EPC STORMWATER REVIEW COMMENTS
IN ORANGE BOXES WITH BLACK TEXT

VOLLMER SUBSTATION

GRADING, EROSION, & SEDIMENT CONTROL PLAN

PPR2147

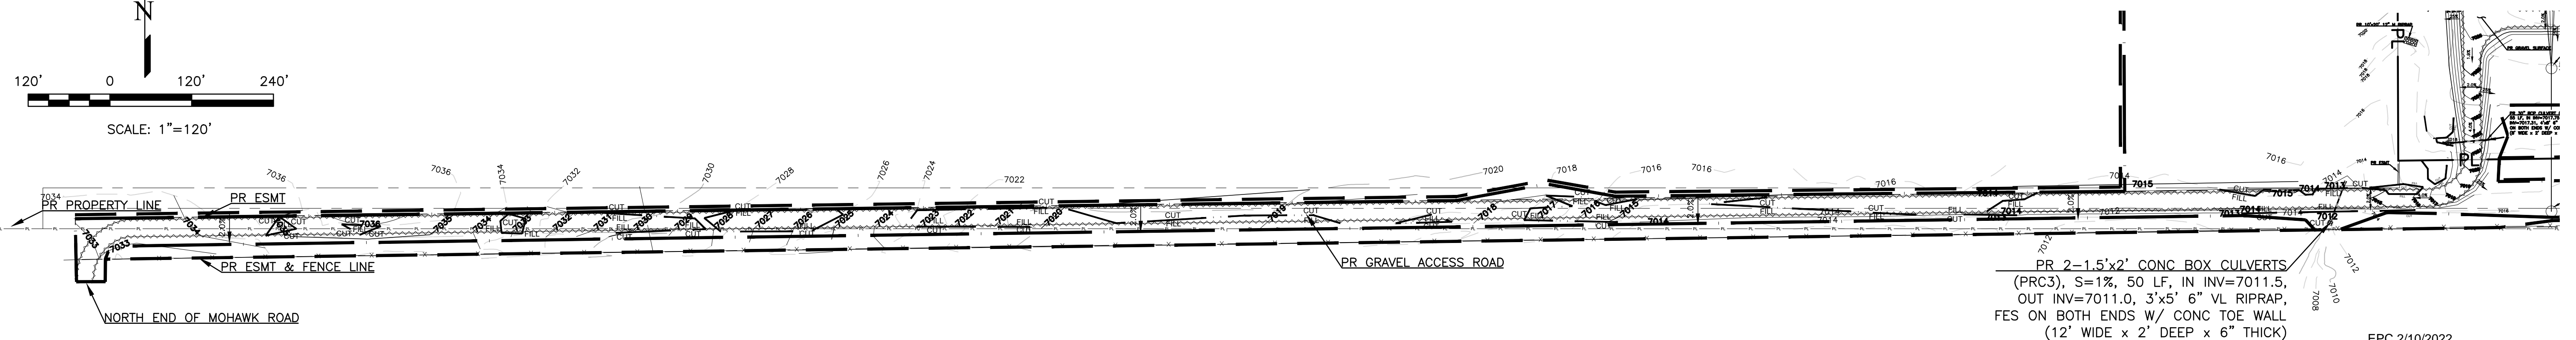
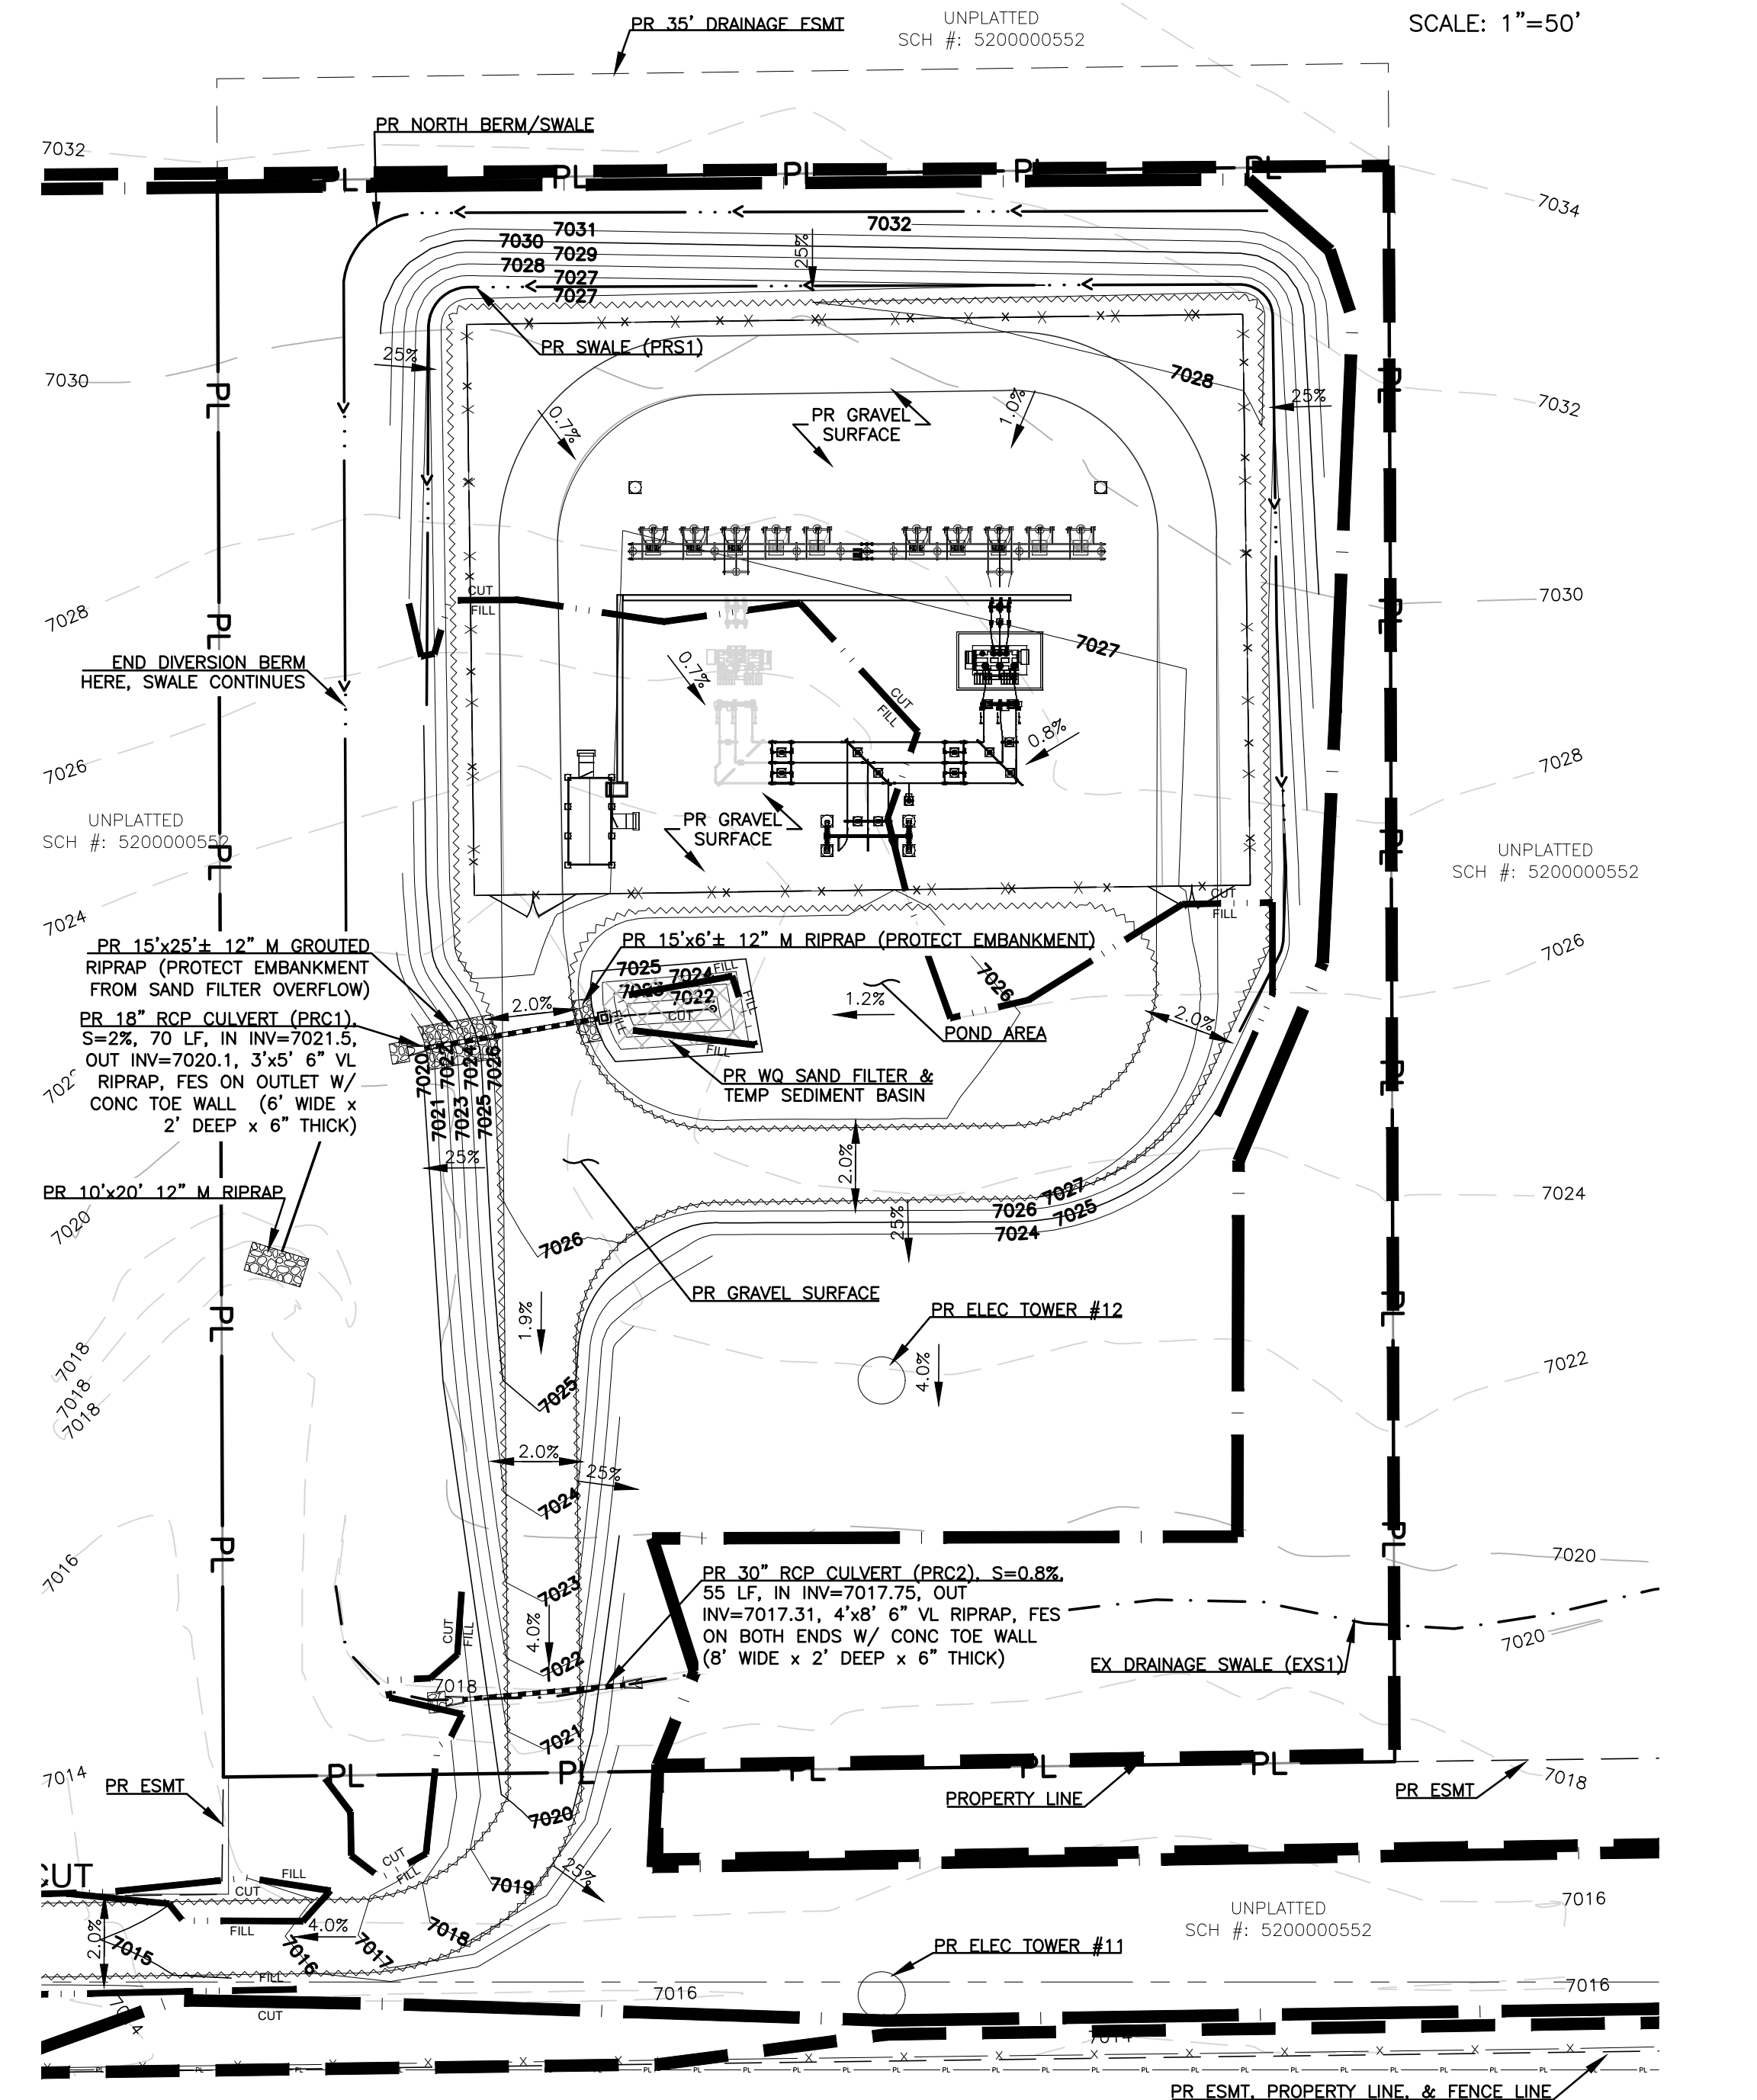
The soils report that was uploaded with AASI196 is from Terracon. Clarify where the CTL-Thompson report can be found and/or change to Terracon. For either report, since one is not uploaded with PPR2147, specify what PCD filing # it can be found under and what date the report was prepared).

Missing 3rd paragraph.
See GEC Checklist item "j"

NOTE: THIS IS AN OLD SET OF PLANS, THE CURRENT SET OF PLANS WAS DATED 03/18/20

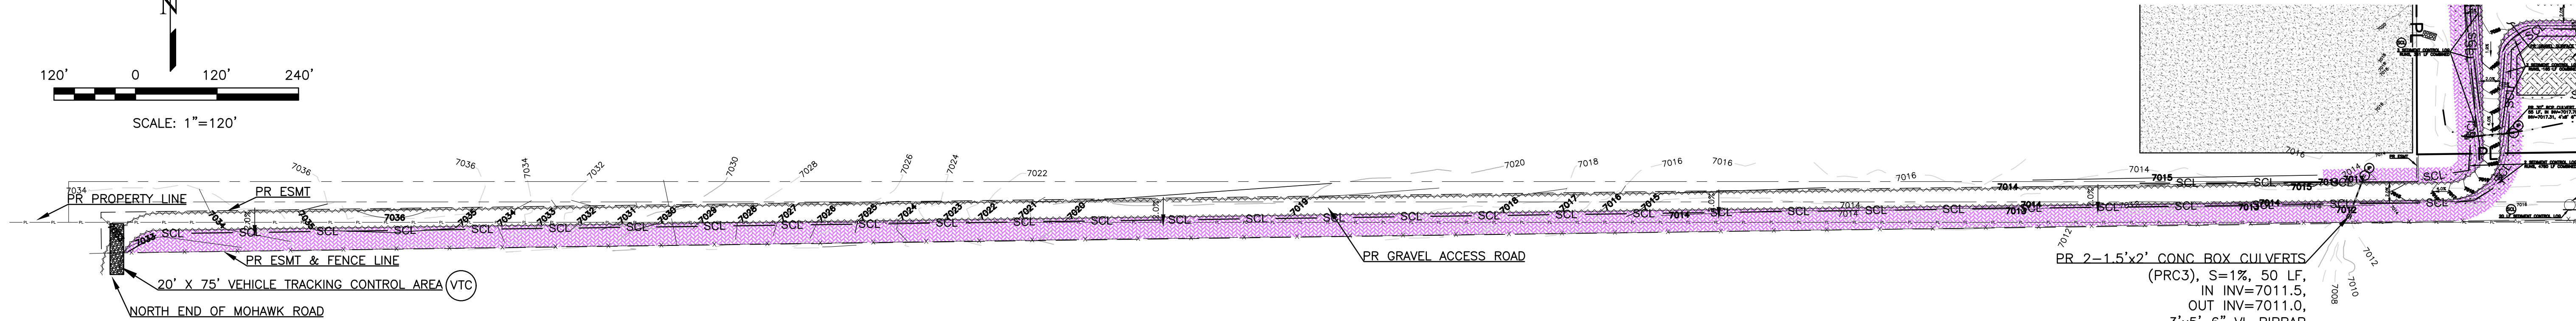
Checklist Item "b" - label adjacent parcels/subdivisions

IT'S SURROUNDED BY A 170 ACRE UNPLATTED PROPERTY, I ADDED SOME UNPLATTED CALLOUTS, BUT THERE NO PLATS OUT THERE YET.
